TO: Jean Fraser
FROM: Dan Goyette, PE and Megan LaPierre, EIT
DATE: May 19, 2008
RE: Portland Museum of Art, Spring Street Site Plan

Woodard & Curran has reviewed the revised site plan application for the Portland Museum of Art Spring Street parking lot. The Museum has purchased the former YWCA property located at the corner of Spring Street and Walnut Street, and is proposing to construct a 45-vehicle parking lot for museum employees. The project will include extensive landscaping and the construction of a bioretention cell for stormwater treatment.

- Letter to Jean Fraser, Planner, from by Stephen R. Mohr, Mohr & Seredin Landscape Architects, Inc., dated May 6, 2008.
- Engineering Plan Sheets, B-1, L1.0 to L5.0, L5.1, L5.2, and C-1 to C-4, prepared by Mohr & Seredin Landscape Architects, Inc. and Land Consulting Engineers on behalf of the Portland Museum of Art, dated May 7, 2008,

7 CITY OF PORTLAND BRICK SIDEWALK/CURB DETAIL  
L5.1 NOT TO SCALE

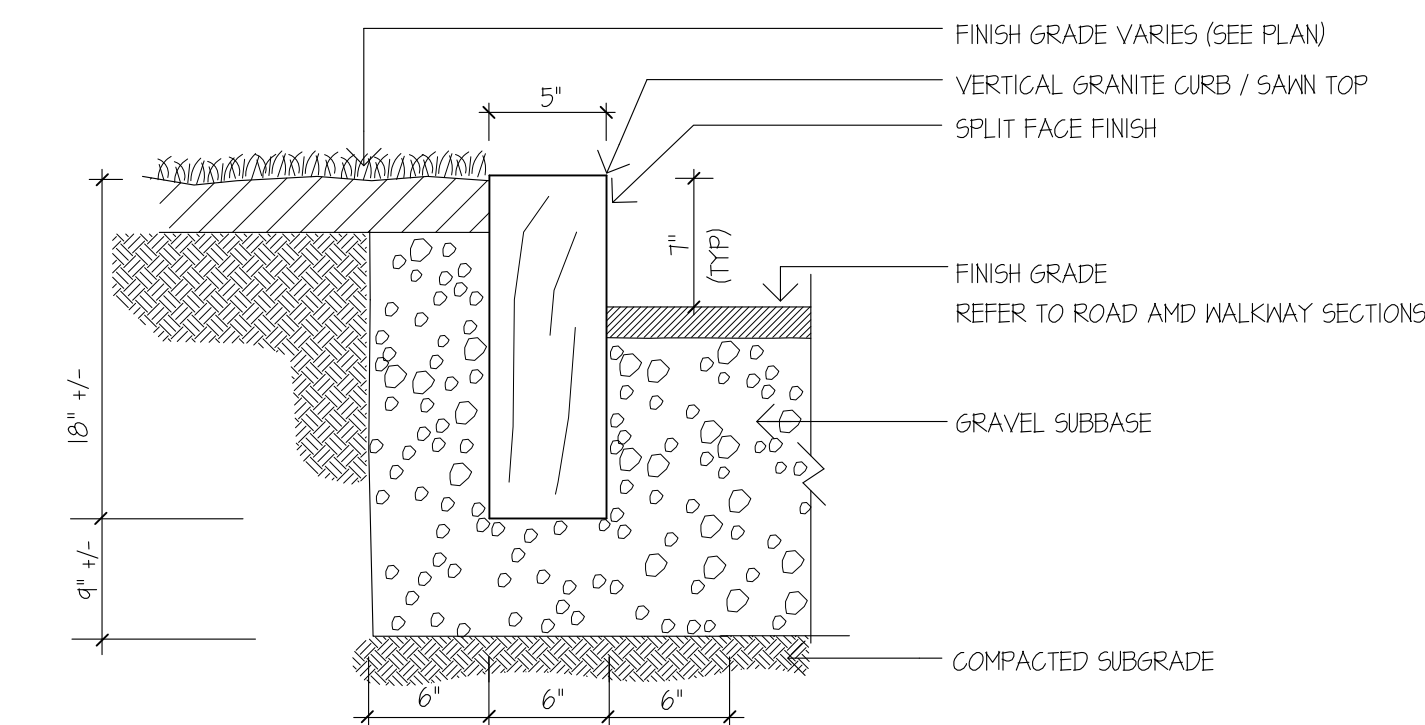
- Notes have been added to sheet L2.0 to instruct contractor to repair the damaged area of the concrete sidewalk per City of Portland Technical Standards. A concrete sidewalk detail should be provided.
- It was noted that the proposed bioretention cell has a ponding depth of 18". Maine DEP standards for BMPs call for a maximum ponding depth of 6" to allow for plant growth. Woodard & Curran finds the 18" ponding depth acceptable as long as the application can ensure the selected plants will survive. However, we would recommend the applicant also get approval from the DEP.
